From: JWArchitecture - john
Sent: 29 August 2015 12:29
To: Simon Davis
Cc: Peter Greenwood; Sandy White
Subject: 11 Marquis Way - Aldwick - AW/181/15/HH

Following our meeting last Monday, I confirm that we have amended six of the relevant drawings and enclose now updated versions of PL05C, PL10C, PL11D, PL12D, PL13D, PL17F and PL18F, to illustrate the following agreed amendments:

project: 11 Marquis Way - Aldwick			
drawing title: Proposed Elevations - East and West			
drawing status: Planning Application			
date: 28 - 08 - 2015	scale at relevant drawing size 1 : 50 (A1) or 1 : 100 (A3)	no: JW131105 - PL18	rev: F

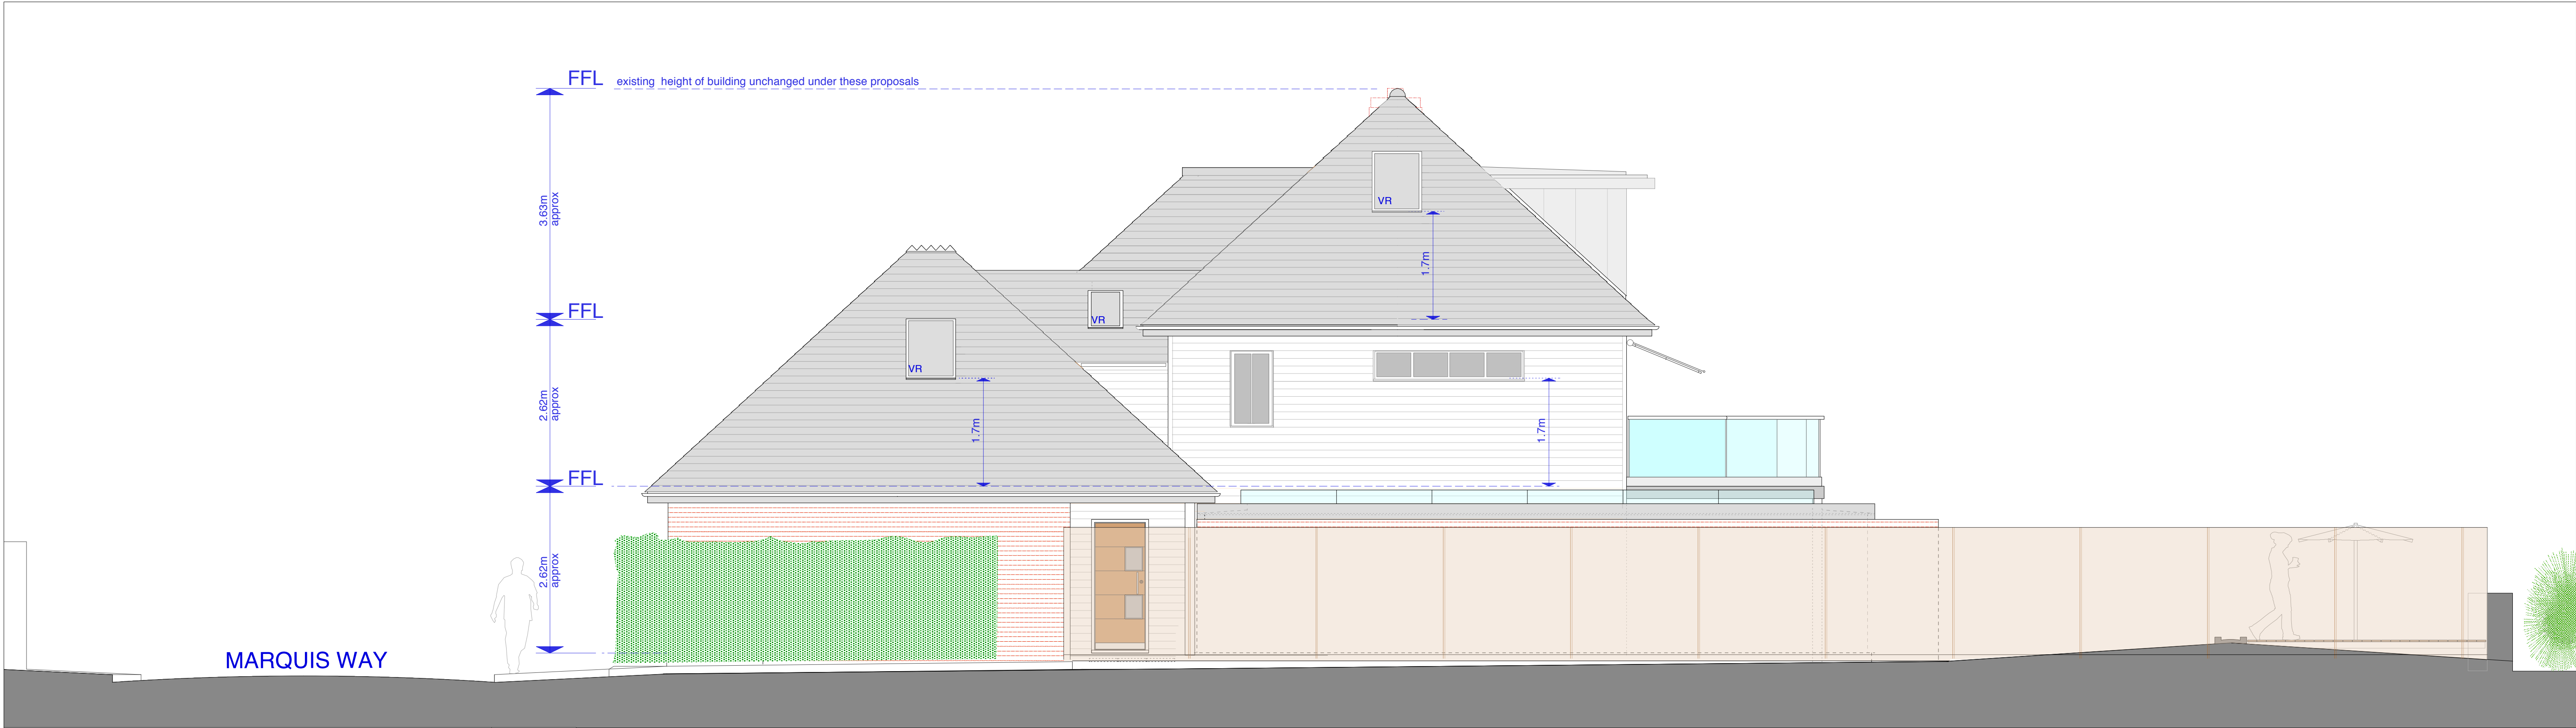
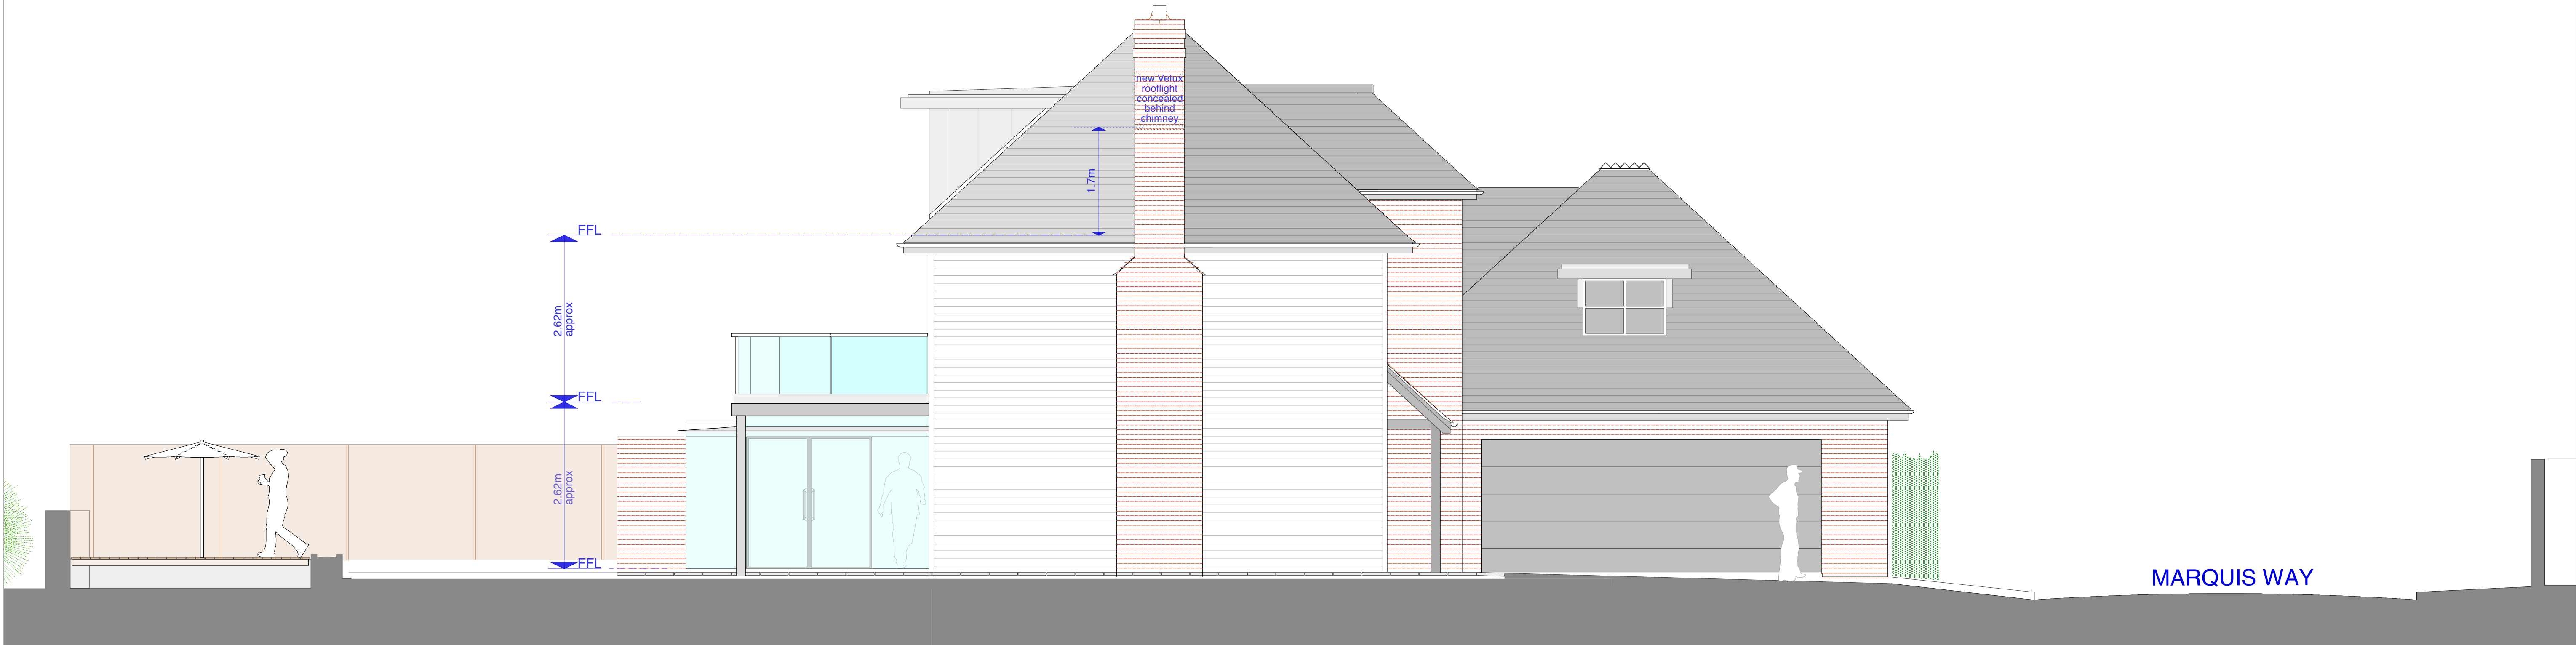
- the raising of the bottom cill height of the proposed new side window, facing west, to ensure that the top edge of the fixed solid frame is no lower than 1.7m above internal FFL. The four windows in this framed opening will be clear glazed and openable, but will be inward opening, hinged along the bottom edge of the window.

- The proposed Velux roof lights will similarly be set at 1.7m above internal FFL, as described above and will be clear glazed units. They will however be the standard centre horizontal pivot or top hung outward opening. The FF bathroom Velux would be slightly higher than this.

no:
JW131105 - PL10

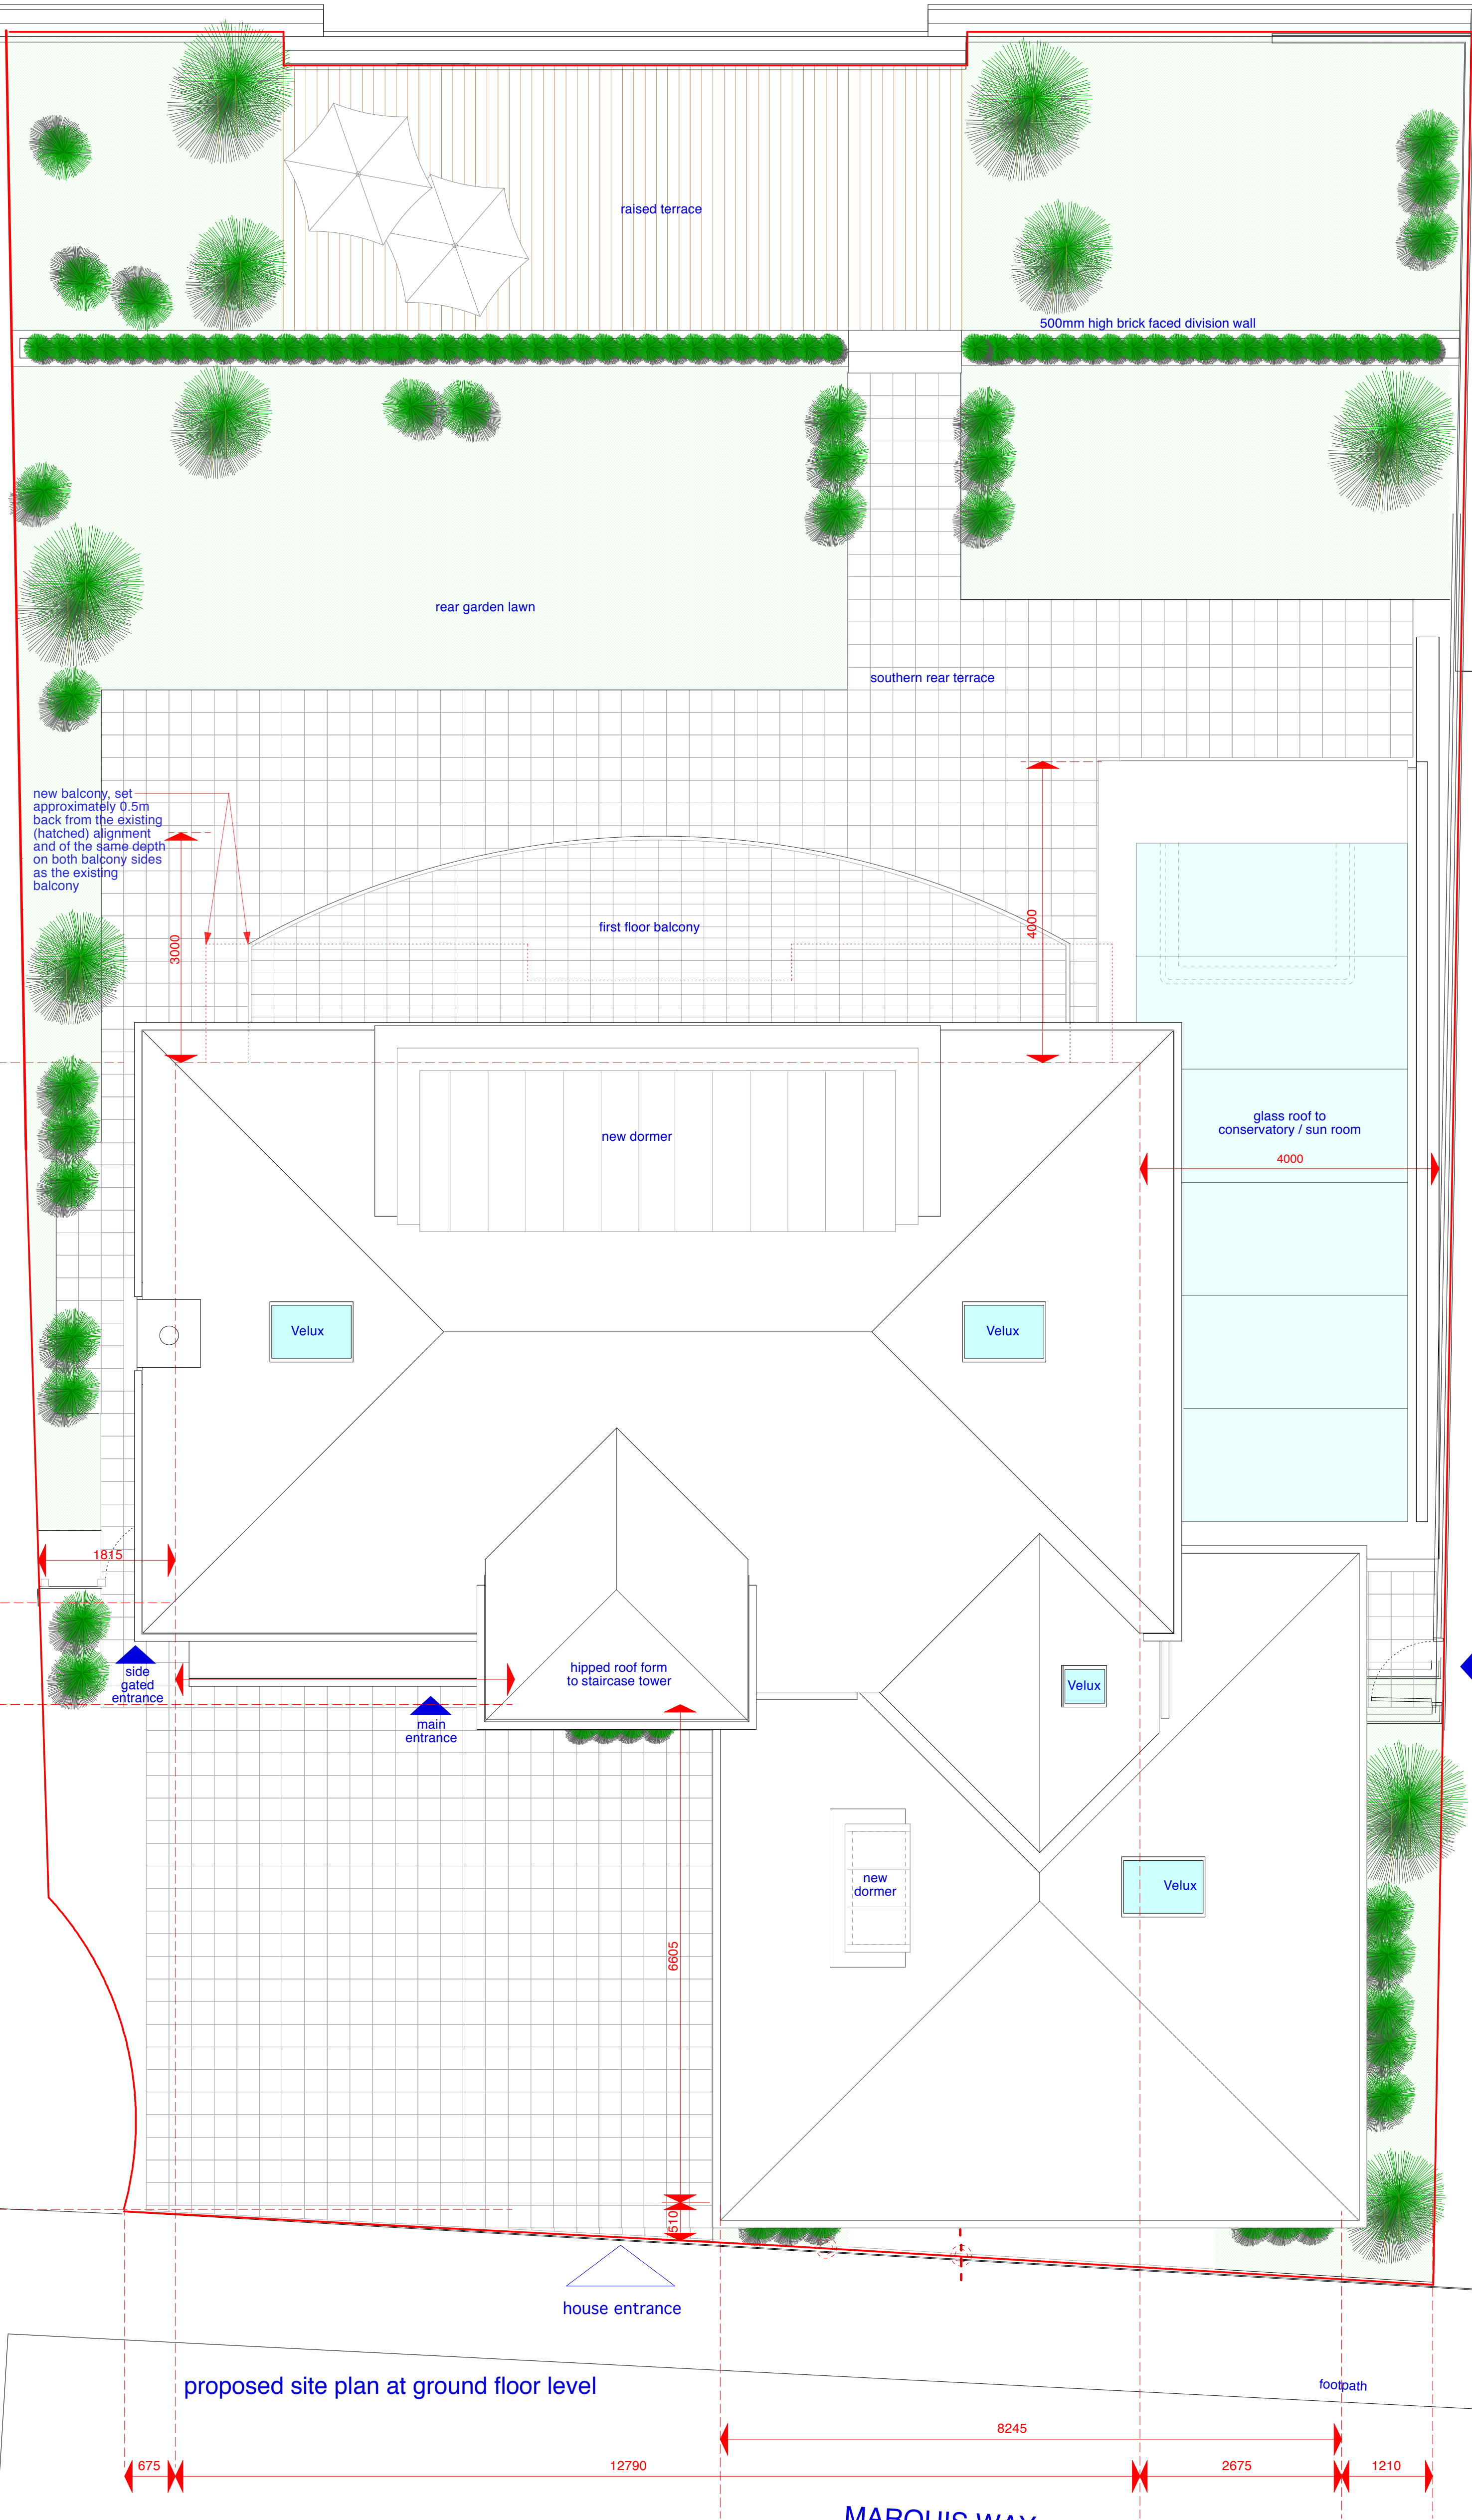
- the reduction in area of the proposed balcony, now with a curved front balcony to the same depth, yet with sides of no greater depth than exists at present. The balcony overall width will remain the same as originally proposed, which is approximately 1.0m narrower than the existing balcony, so setting the alignment of the balcony 0.5m further away from the boundaries on both sides, than exists at present.
